EPA Advice on Environmental Impact Statement – SSD-62855708, 2 - 4 Hale St Botany NSW

Thank you for the request for advice from Public Authority Consultation (PAE-74322458), requesting the review by the NSW Environment Protection Authority (EPA) of the Environmental Impact Statement (EIS) for the proposed Waste Management Facility, Botany (Application (SSD-62855708) at 2-4 Hale Street, BOTANY, NSW 2019.

Drawing Title  
**WAREHOUSE PLAN**

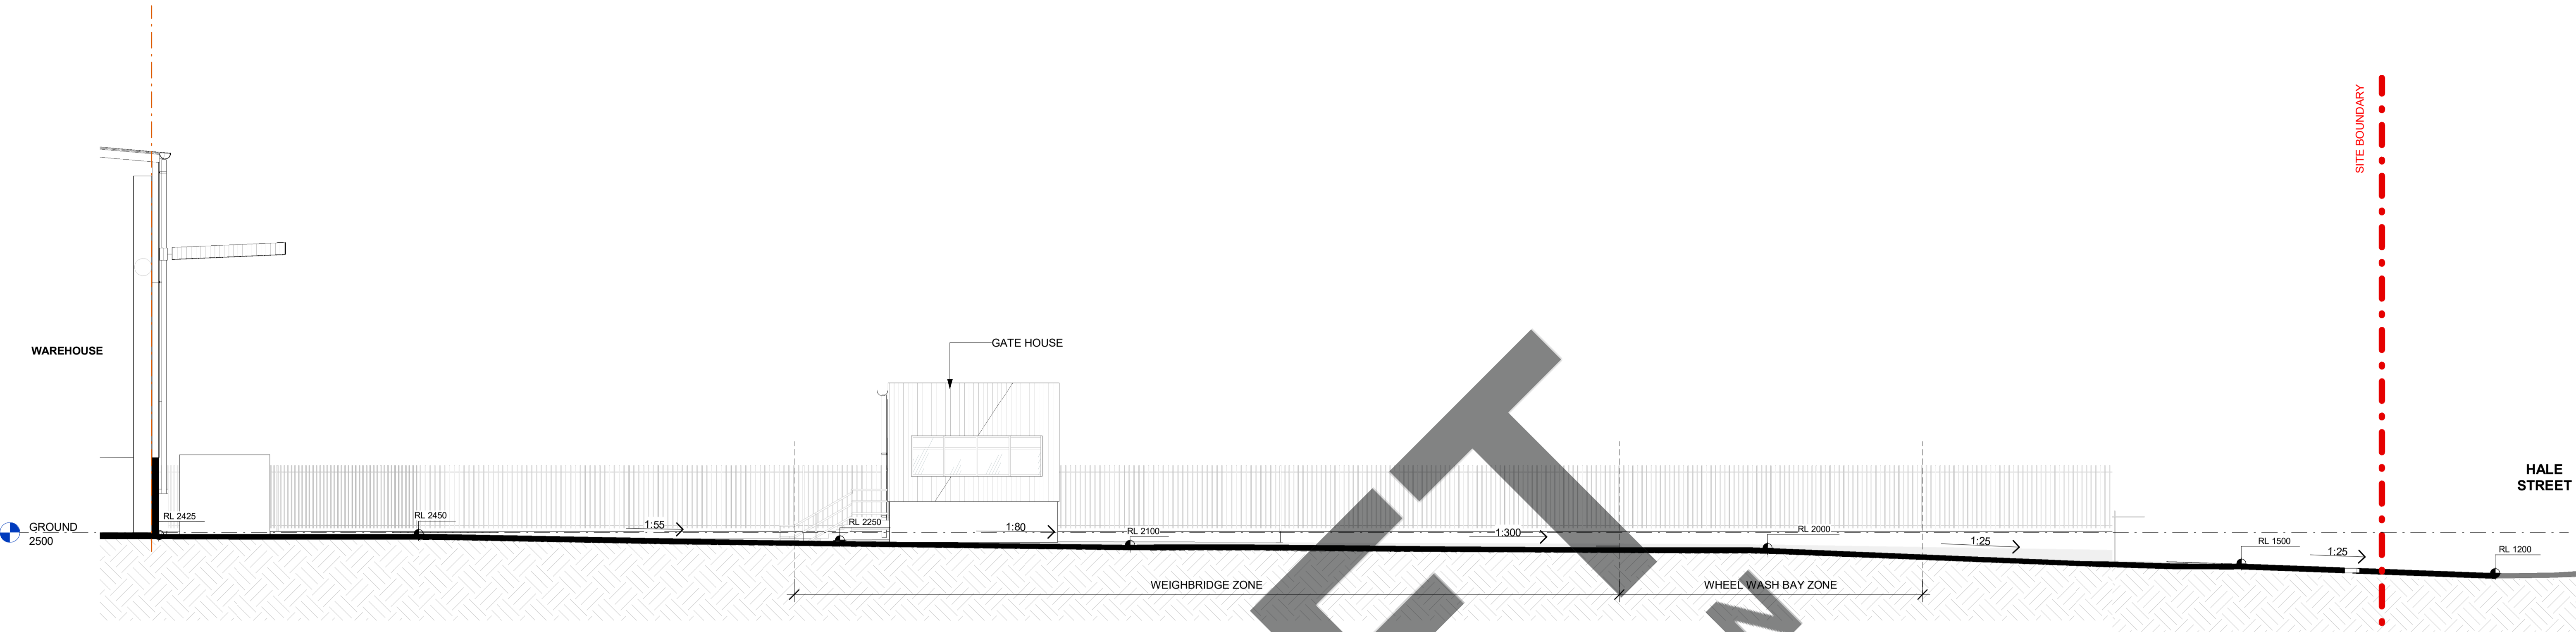
- The NVIA has not explicitly identified the proposed construction details of the warehouse that were considered in the noise modelling. Furthermore, the assessment has not provided specific recommendations regarding the warehouse's construction to

ensure compliance with the established acoustic goals. It is essential to include detailed information about the warehouse construction requirements necessary to meet the confirmed PNTLs within the NVIA.

Figure 15 | Noise Catchment Areas and Noise Monitoring Locations

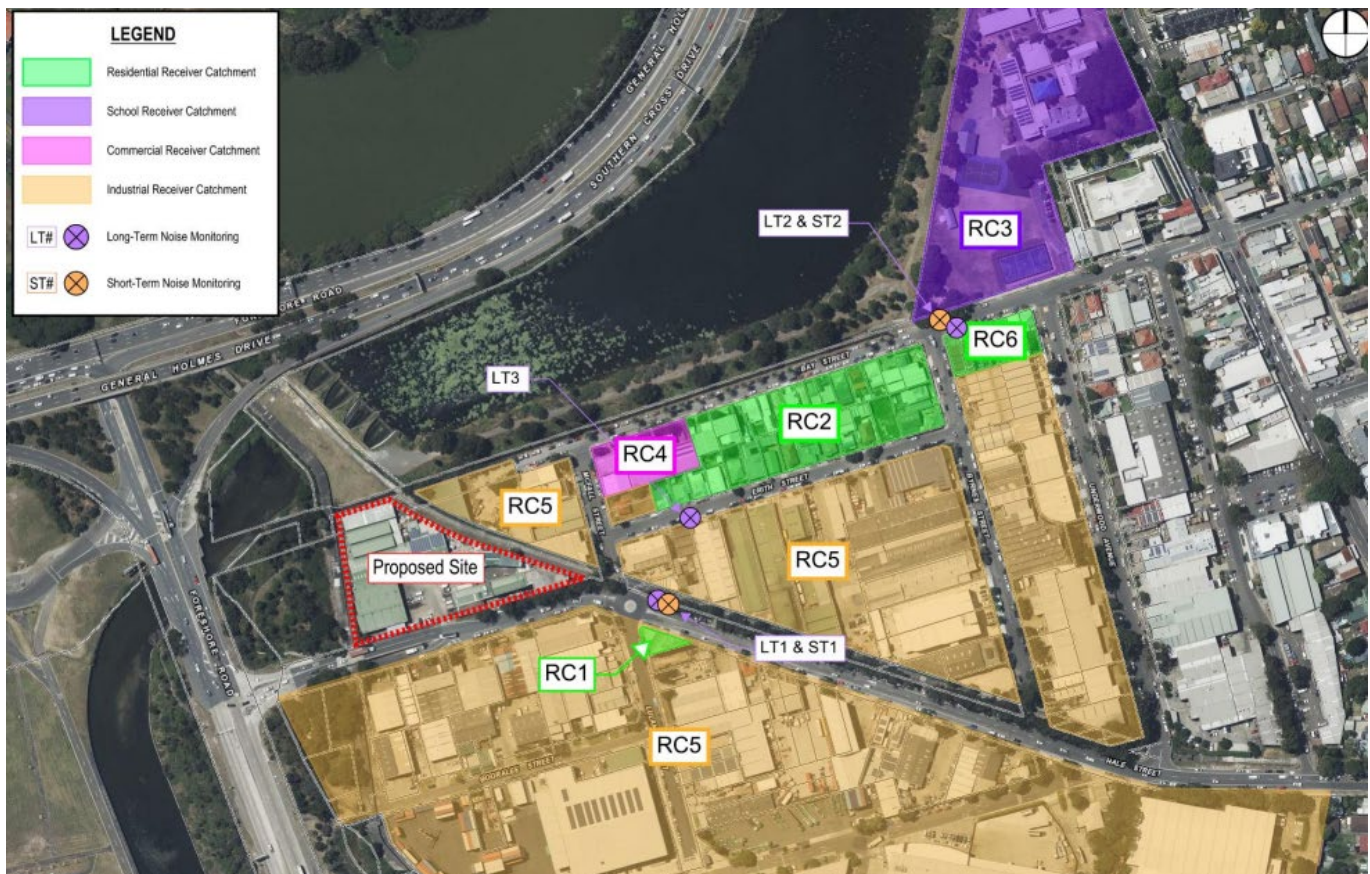
- The assessment has categorized nearby residential areas into two groups: RC1 and RC2. As shown in Figure 1 and Table 2 of the NVIA, RC1 is a residential area located within the industrial zone, approximately 80 meters from the proposed development. While the specific addresses of the residential dwellings within RC1 have not been provided, ambient noise monitoring has been conducted at a location identified as LT1 - 3 Hale Street Botany, at the corner of Luland Street. Based on the information presented in Figure 1, it appears that LT1 and RC1 are likely located at 3 Luland Street Botany, rather than 3 Hale Street Botany. Further clarification regarding the exact locations of RC1 and LT1 is necessary.

- The assessment currently does not include or consider the potential noise impacts on residential properties located on Erith Street, approximately 100 meters from the proposed development. It is essential to evaluate the noise exposure of residences on the northern side of Erith Street within the NVIA.

- Noise Monitoring Equipment: The NVIA indicates that long-term ambient background noise monitoring was conducted at three locations: LT1, LT2, and LT3. The monitoring equipment used was a Convergence Instruments Sound Level Meter Data Logger (NSRT_mk3 Type 1). However, the Noise Policy for Industry (NPfI) stipulates that background noise levels should be measured using a noise data logger that meets the accuracy specifications of a Class 2 meter, as defined in AS IEC 61672.1. The Convergence instrument, equipped with a MEMS microphone, is unable to be certified against this standard and therefore does not comply with the NPfI requirements.

- Monitoring Instrument Placement: The NVIA does not provide specific details regarding the placement of the background noise monitoring instruments, such as their height above ground and proximity to reflective surfaces. The NPfI outlines the necessary requirements for the location of monitoring equipment used to assess background noise levels.

It is essential to provide comprehensive information about the micro location of the monitoring instruments, along with an evaluation demonstrating compliance with the NPfl's locational guidelines.

- **Monitoring Location Requirements:** The NVIA indicates that the same monitoring locations, LT1, LT2, and LT3, were used to assess both background noise levels and existing traffic noise levels. However, the locational requirements for measuring background noise and traffic noise differ. The NPfl mandates a free-field location, while the Road Noise Policy (RNP) requires a reverberant location within 1 meter of the exposed façade.

As highlighted earlier, it is crucial to provide a detailed description of the monitoring instruments' micro locations and justify their compliance with the specific requirements of both the NPfl and RNP. Depending on the actual placement, adjustments to the measured noise levels may be necessary.

Furthermore, it is unlikely that the noise levels measured at LT1 or LT2 accurately represent the noise exposure experienced by residents on Erith Street Botany.
